**RE: TRONOX RESPONSES TO COMMENTS ON THE SNAPPER MINE NORTHERN
EXTENSION MODIFICATION SUBMISSIONS REPORT**

TRONOX RESPONSES TO COMMENTS ON THE SUBMISSIONS REPORT

Table 1
Tronox Responses to Comments on the Snapper Northern Extension Modification Submissions Report

Figure 2

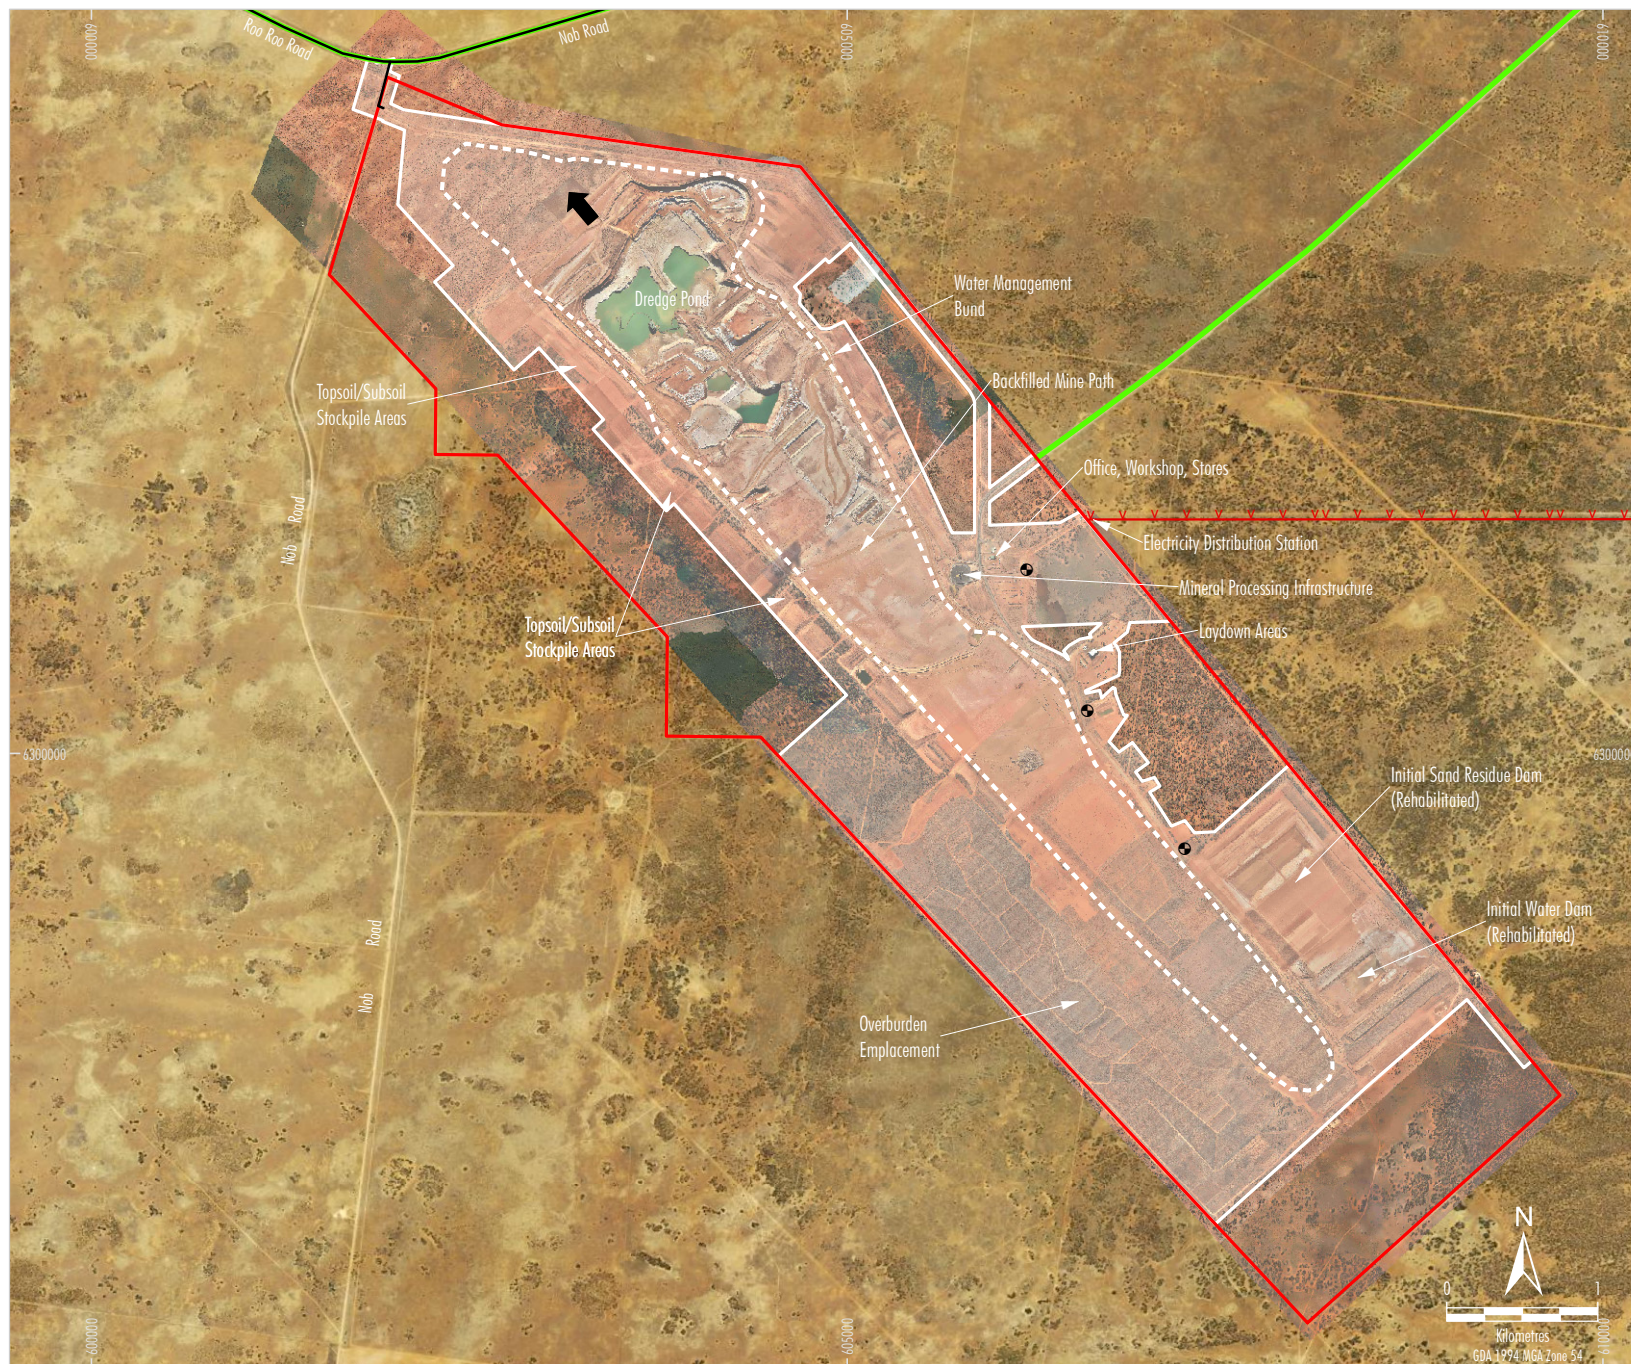
<i>Figure 2 shows the Highway Access Road (HAR) and Mineral Concentrate Access Route as the main access for the Modification; is access to the Modification area immediately adjoining the HAR, therefore access will be using internal roads in the Mining Lease Application Boundary (MLA 1) only?</i>	Access to the Snapper Mine will continue to be provided by the ‘Mineral Concentrate Transport Route and MSP Process Waste Transport Route’ which enters ML 1621 on the eastern side of the Snapper Mine (Figure 2 of the Submissions Report). Access to MLA 1 would be provided by existing internal haul roads within ML 1621 (i.e. no separate access to MLA 1 is proposed as part of the Modification).
	<i>The department notes that even though the re-alignment of Nob Road will be outside of the MLA 1, if the works to re-align the road are included in the Modification, then an easement acquisition for the proposed new road casement will be required.</i>	Tronox is consulting with Crown Lands, the Wentworth Shire Council (WSC) and the relevant leaseholders regarding the Nob Road realignment and will obtain the relevant approvals under the <i>Crown Land Management Act 2016</i>.
